Our Ref: R/2025/16/A
File No: 2026/041860
Your Ref: SSD-75493483

Advice on RTS – Forest Lodge Integrated Seniors Living – SSD-75493483

Thank you for your correspondence dated 28 January 2026 inviting the City of Sydney Council (the City) to comment on the Response to Submissions (RTS) package for the above proposed development.

Title
SECTION 03 - HERITAGE BUILDING

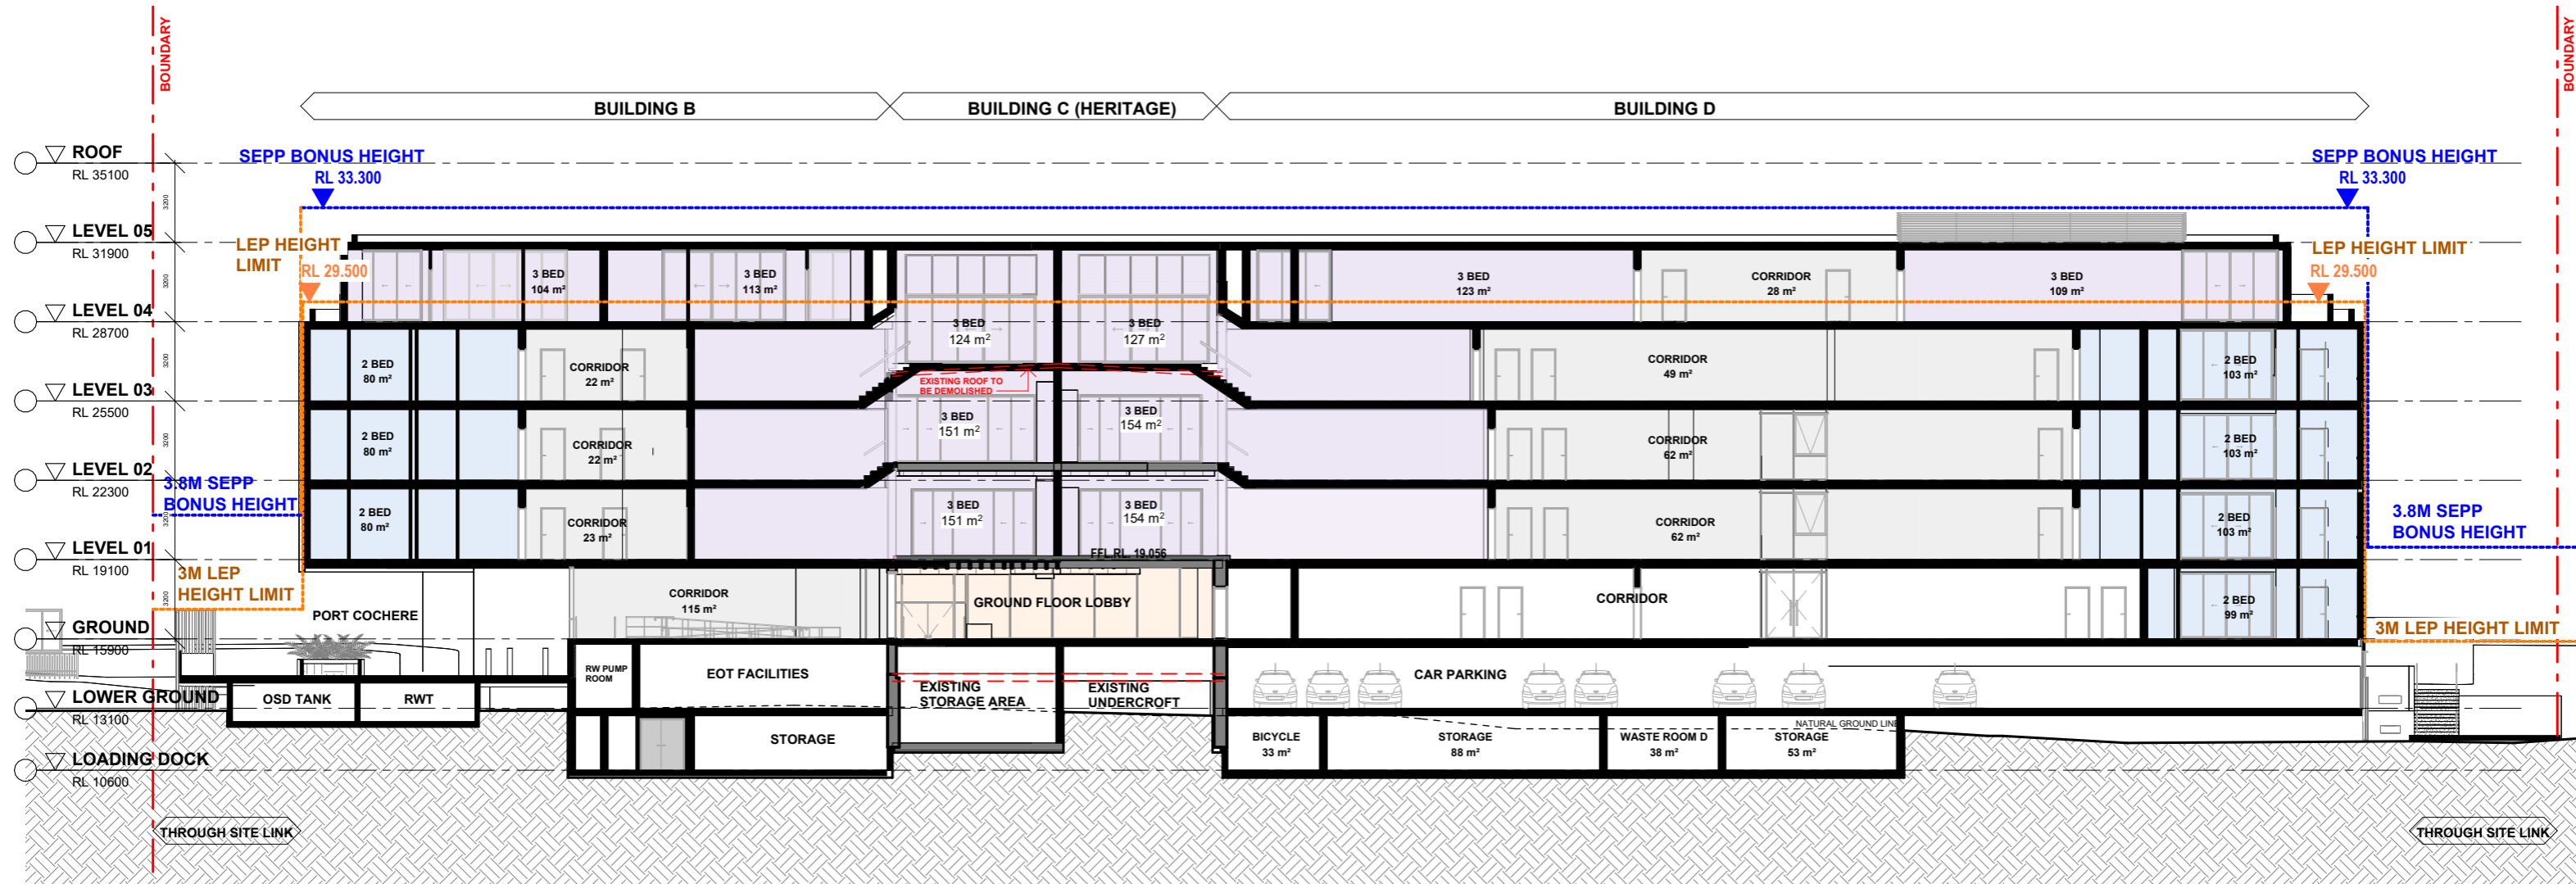
Due to the extent of excavation proposed for the new additions adjoining the former hat factory, the City previously requested that a structural engineering report be provided to outline measures necessary to ensure the structural integrity of the retained heritage building. The applicant has not provided any response to this request. A structural engineering report must be provided.

TITLE
SITWORKS AND DRAINAGE PLAN
GROUND FLOOR

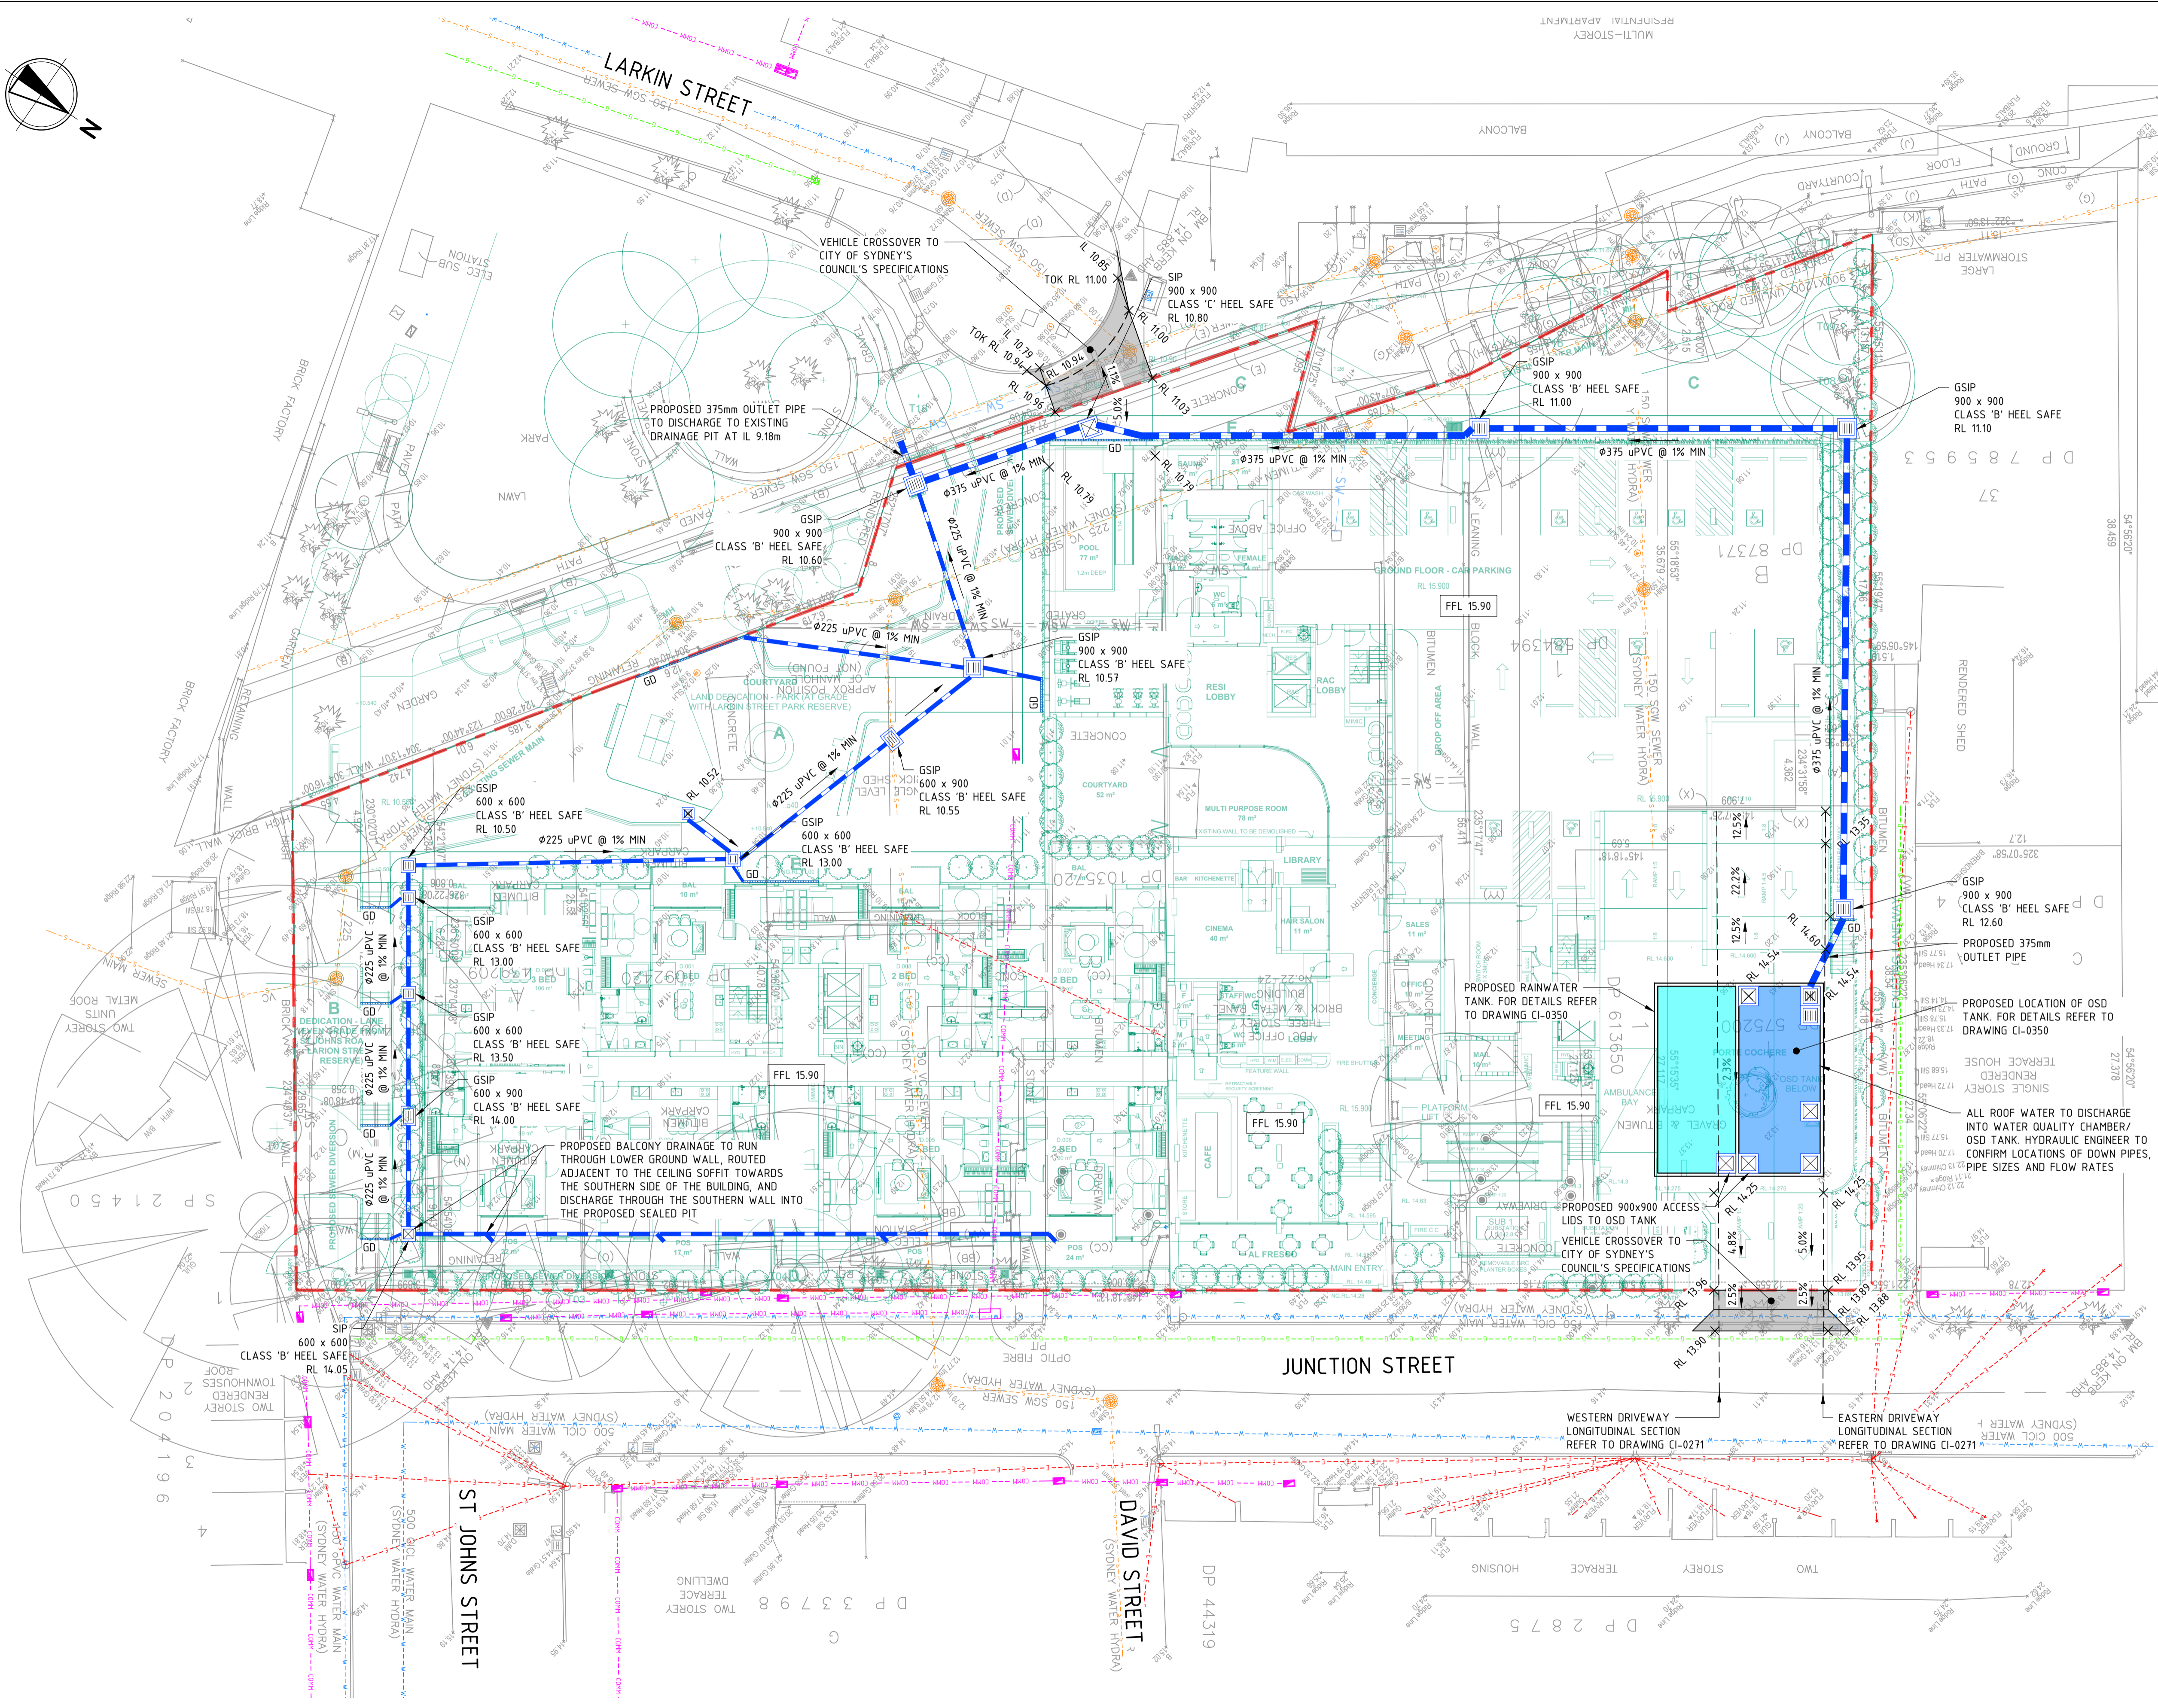
The submitted Water Management Plan remains inadequate to provide a comprehensive assessment of the site's drainage requirements and demonstrate compliance with Section 3.7.2 of Sydney DCP 2012. The following critical information remains missing:

- identification of catchment areas, impervious/pervious areas, and overland flow paths on the plans
- invert levels and grades for the proposed and existing drainage systems
- flow calculations for minor and major drainage design events and
- an assessment of the downstream system capacity to verify that the proposed OSD discharge can be accommodated.

The submitted Water Management Plan also relies on the proposed OSD tank to justify compliance. However, it does not include the necessary analysis to confirm compliance on hydrology, AEP flow management, downstream pipe capacity, safety of major flow paths, or stormwater source control measures.
